June 23, 2016

Nazish, LLC  
Shakeel Rizvi at [shaky1424@yahoo.com](mailto:shaky1424@yahoo.com)

**Re: Drainage Control Ordinance (14-5-2-1) and NPDES CGP Violations for Erosion and Sediment Control- Sol Vita Subdivision**

Sol Vita Subdivision
Offsite Work

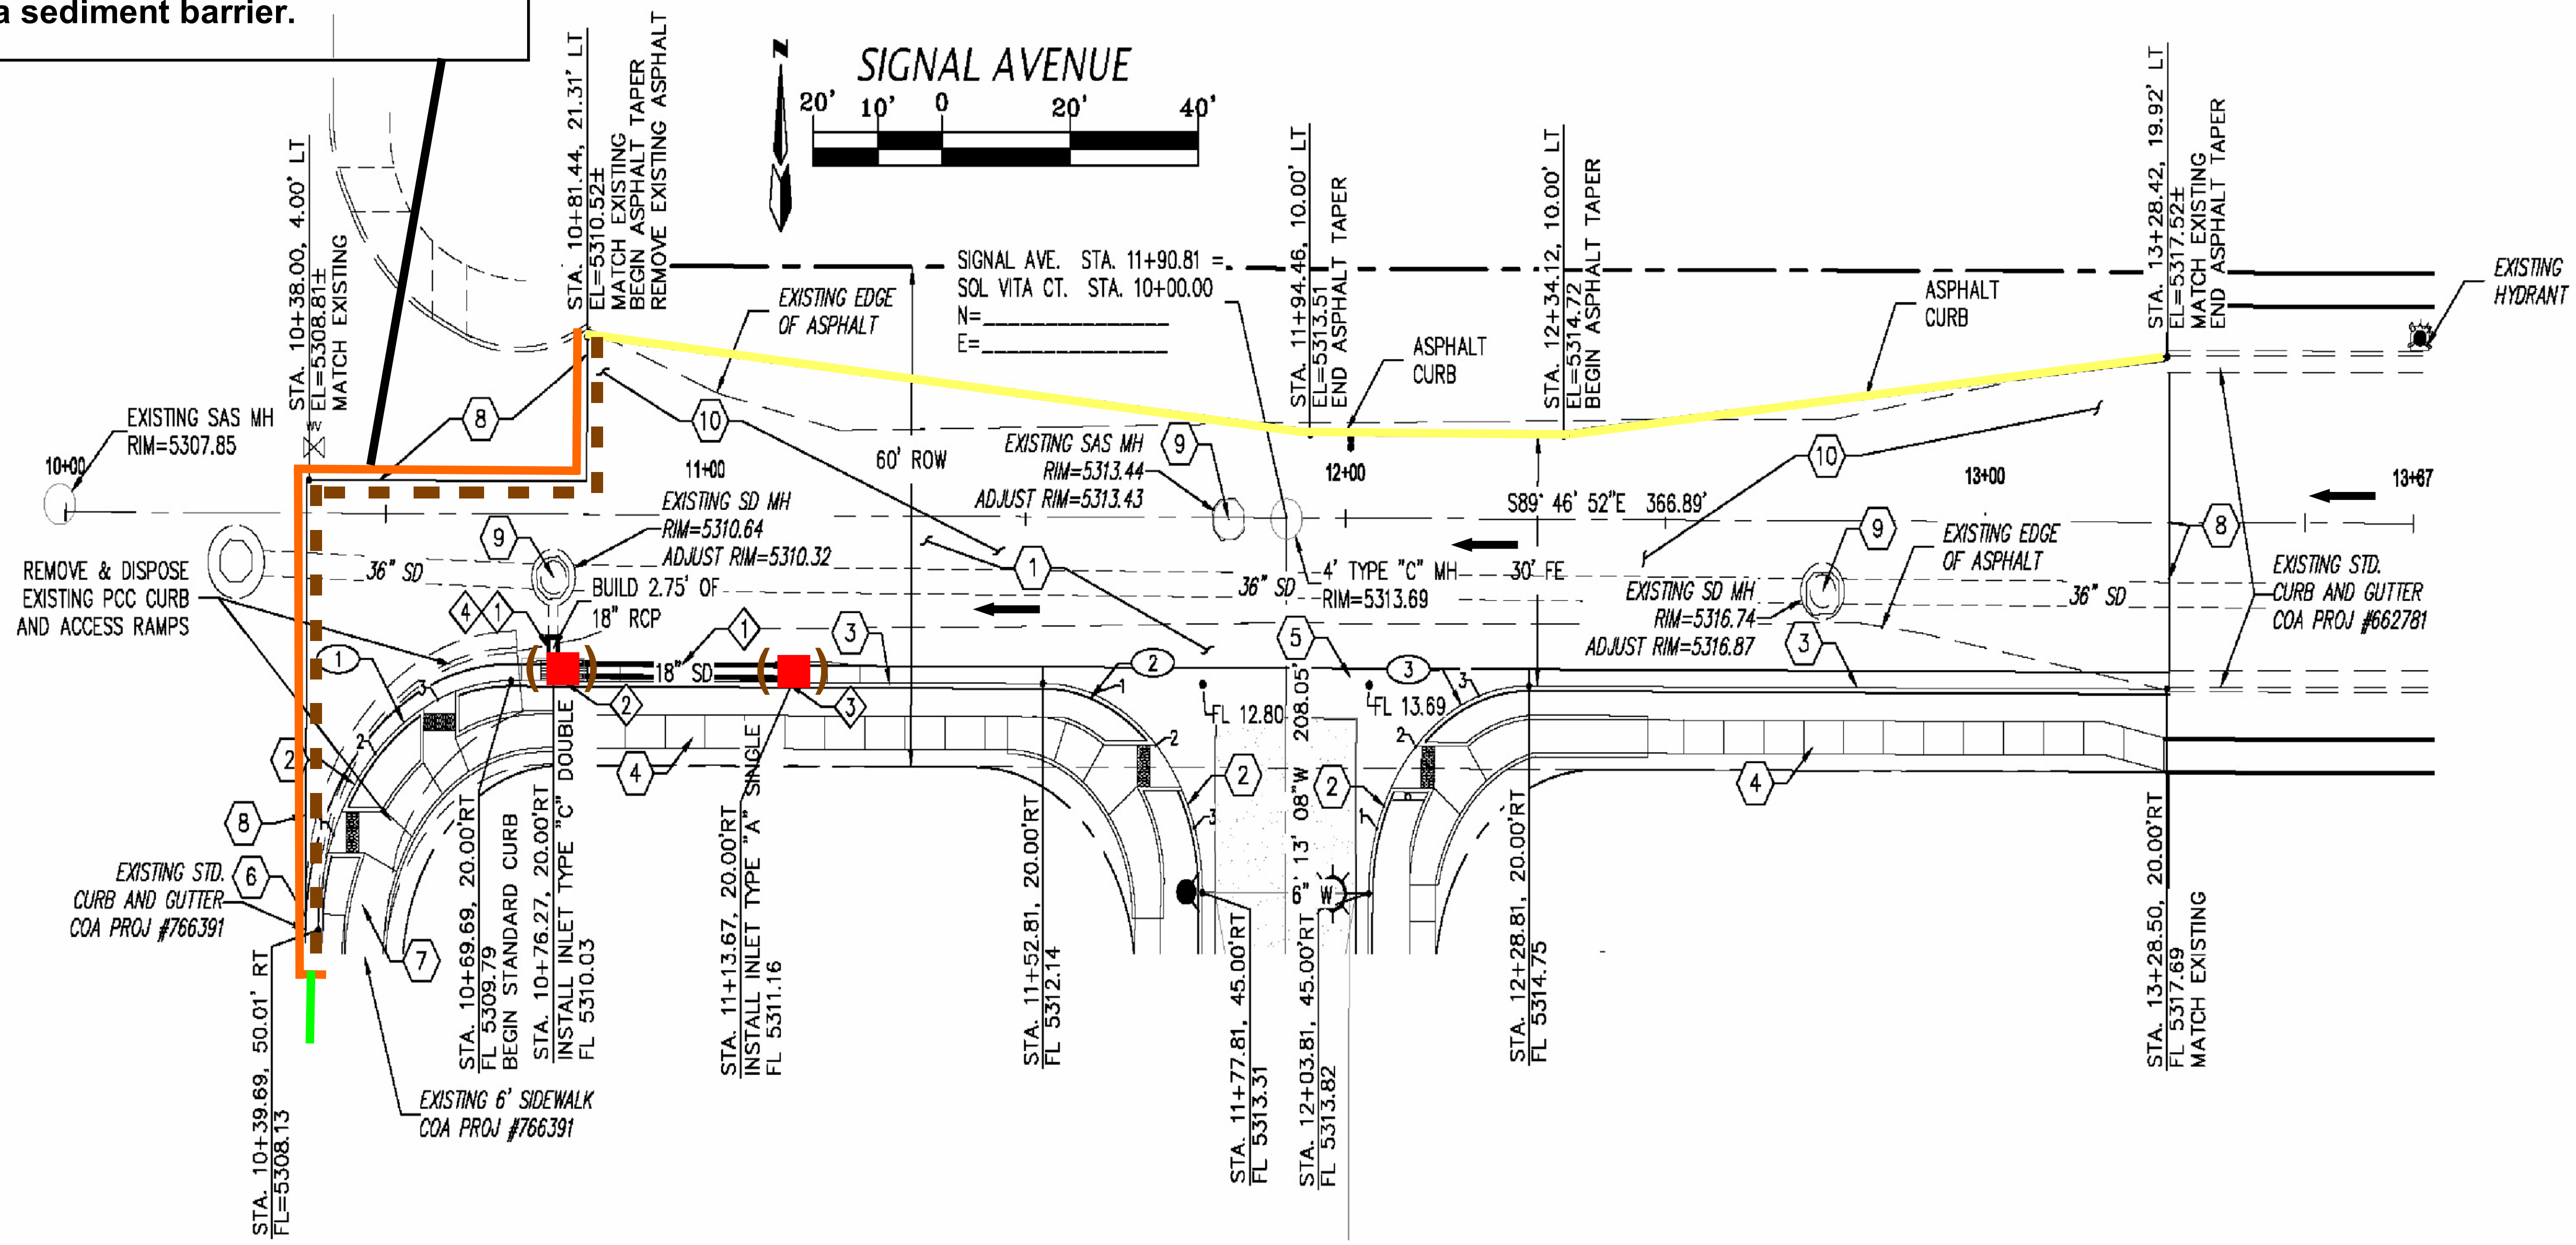
1. Install/maintain the silt fence at the site per approved methods.
2. Provide a sediment BMP for the land south of the development that is being

used for access/staging.
